Recommendation Report for Prior Notification of Work to Tree(s) in a Conservation Area

REF NO: AW/279/20/TC

LOCATION: 128 Manor Way
Aldwick
PO21 4HN

PROPOSAL: Crown reduction to height 8m and spread 6m 2 No. Conifer trees.

SITE PLAN (SC. 1:200)

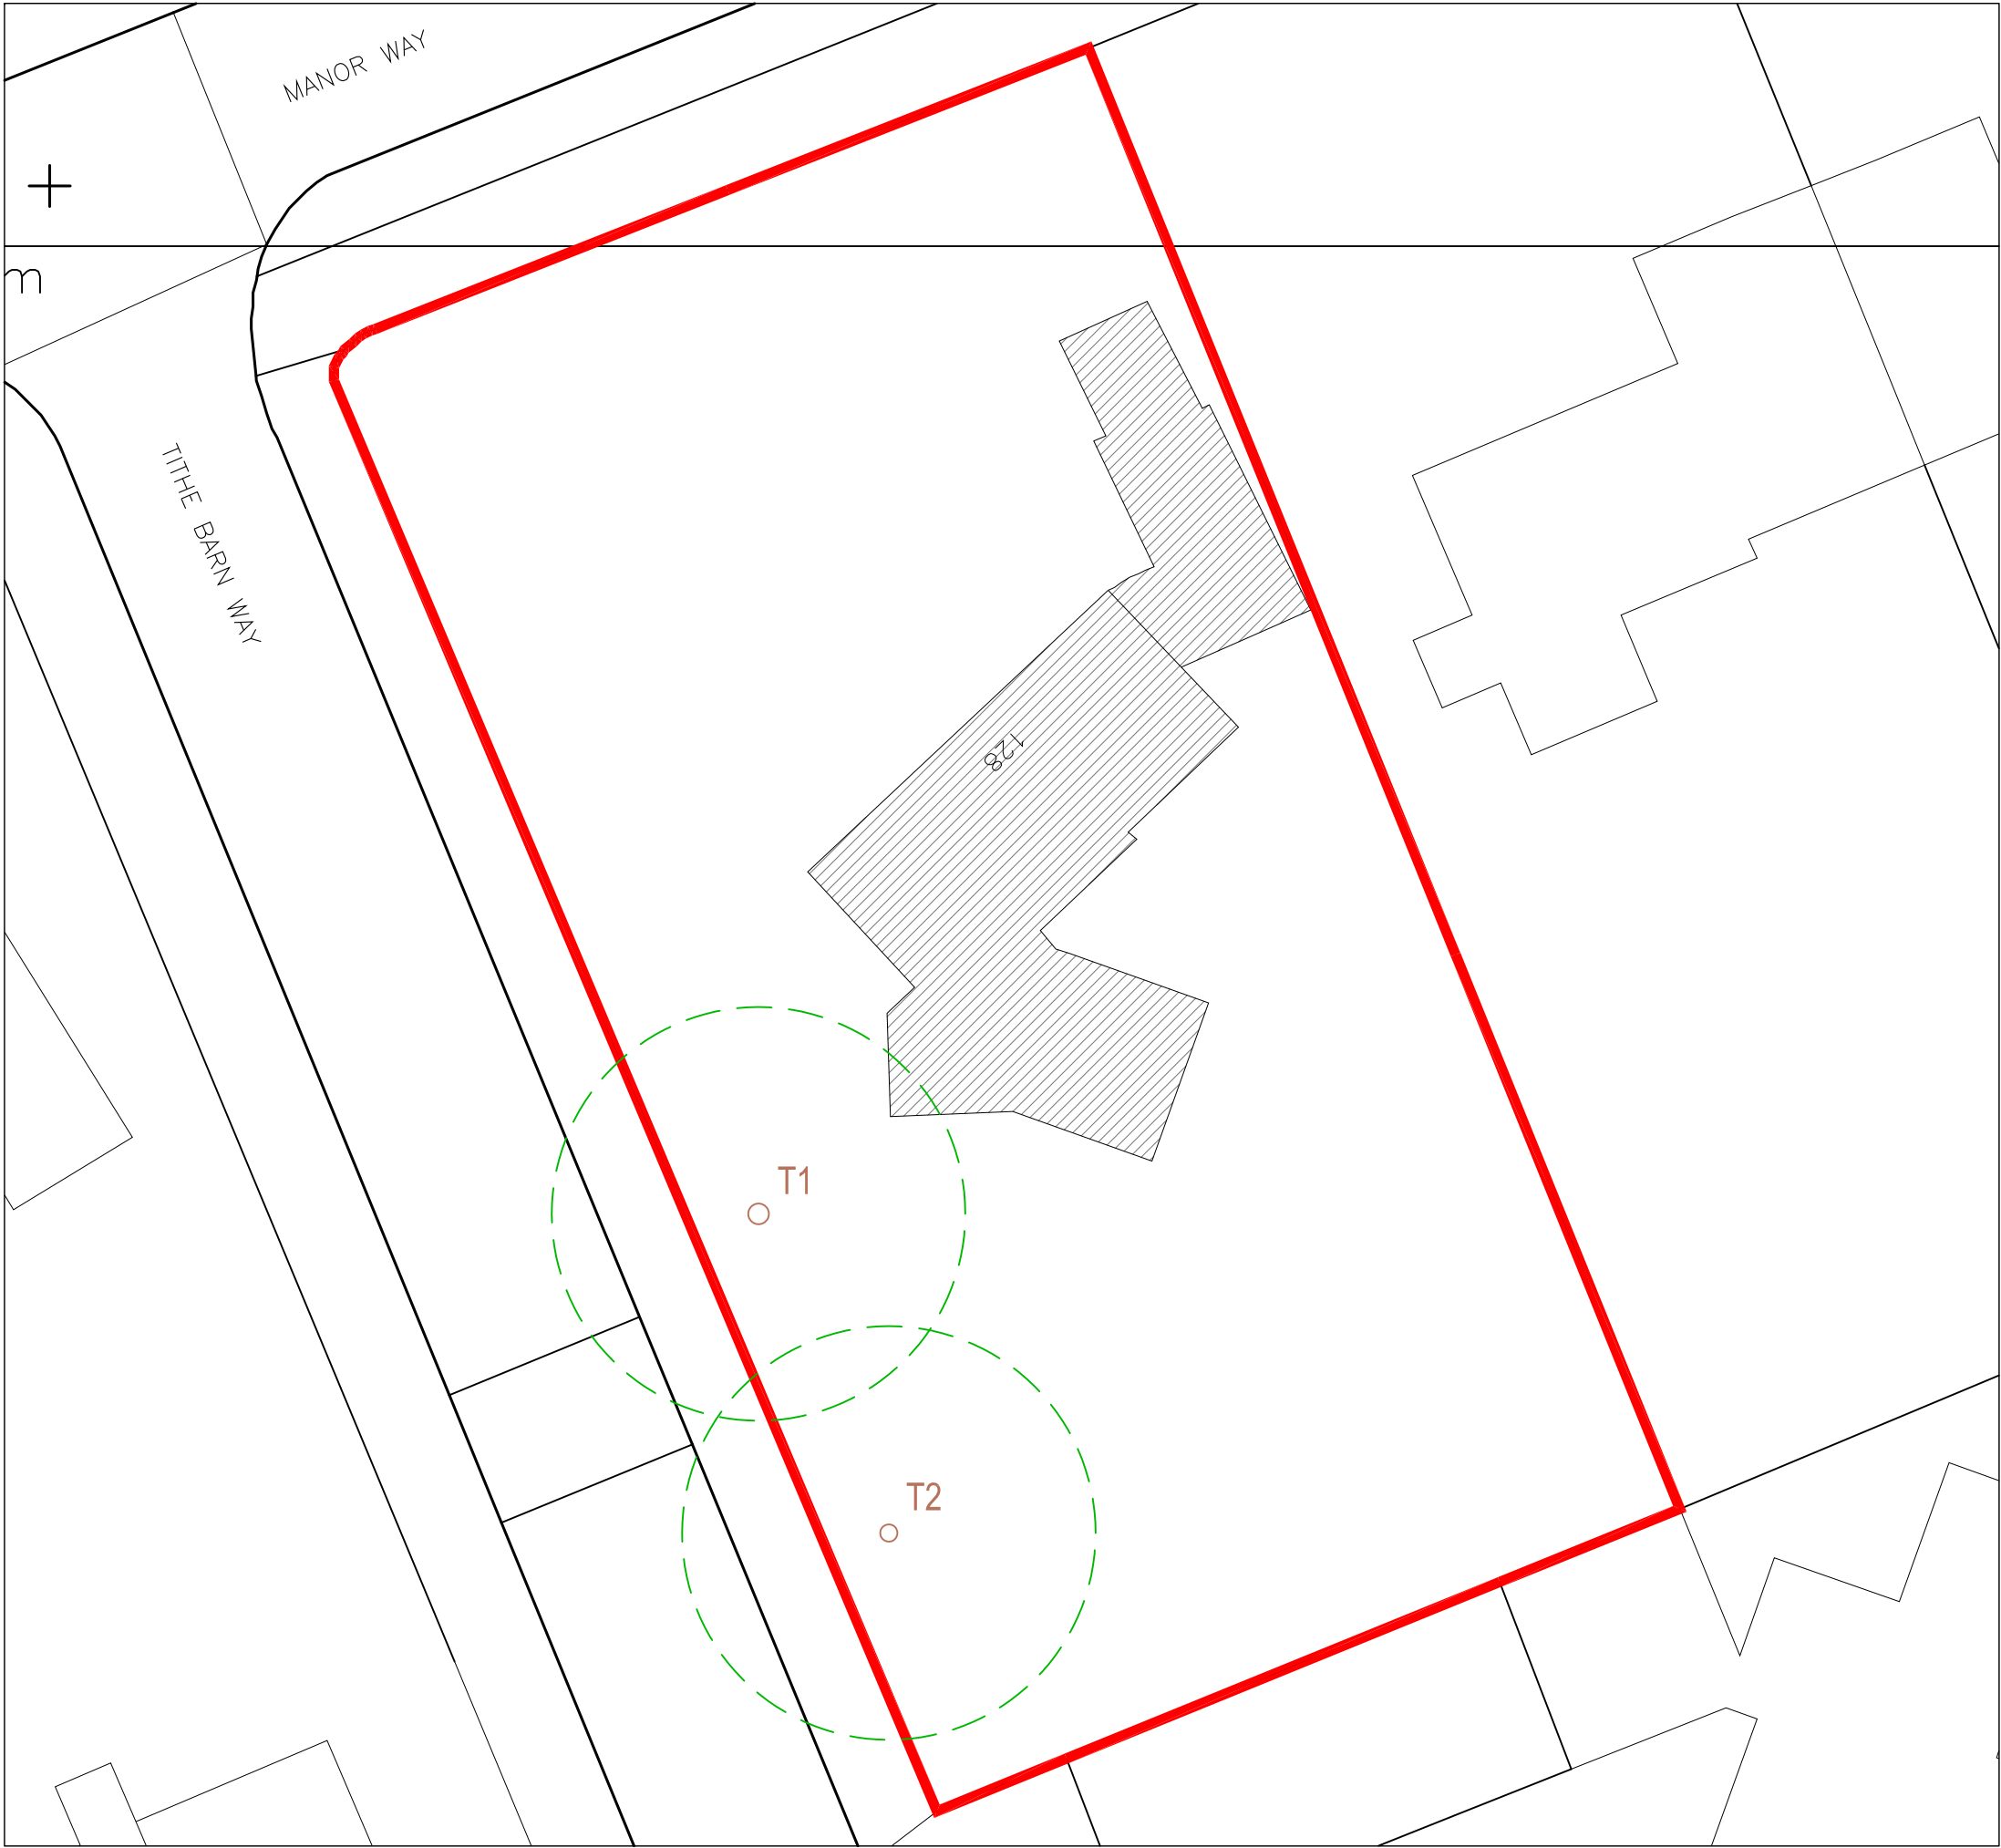
Outwardly and from a distance both trees appear to be in a fair physiological state and free from any obvious significant structural defect. They exhibit unmodified and attractive upper crown profiles. They grow alongside the dwelling and are most prominent when viewed from Tithe Barn Way, a short section of estate road notable for its conifer tree-lined character - of which these trees are notable constituents. As such, they have public amenity value and contribute to the character of the area. In the absence of any documentation to the contrary, I have determined from size alone that neither tree would have been established at the time the sole Tree Preservation Order affecting this plot was made

There is no obvious arboricultural justification for the work proposed. An operation to reduce both the height and lateral spread on all aspects (the correct interpretation of crown reduction) by 4m and 3m respectively would not comply with 'British Standard (BS3998:2010) Tree work - Recommendations' and be likely to result in significant harm to the health and vitality of the trees with large pruning wounds being formed as well as undermining their visual amenity value and impact in the landscape. It may ultimately lead to their destruction.

I register an Objection to this proposal and recommend the making of a Tree Preservation Order to preserve the trees place in the landscape and better control their future management. I attach a TEMPO form and GIS plan for this purpose.
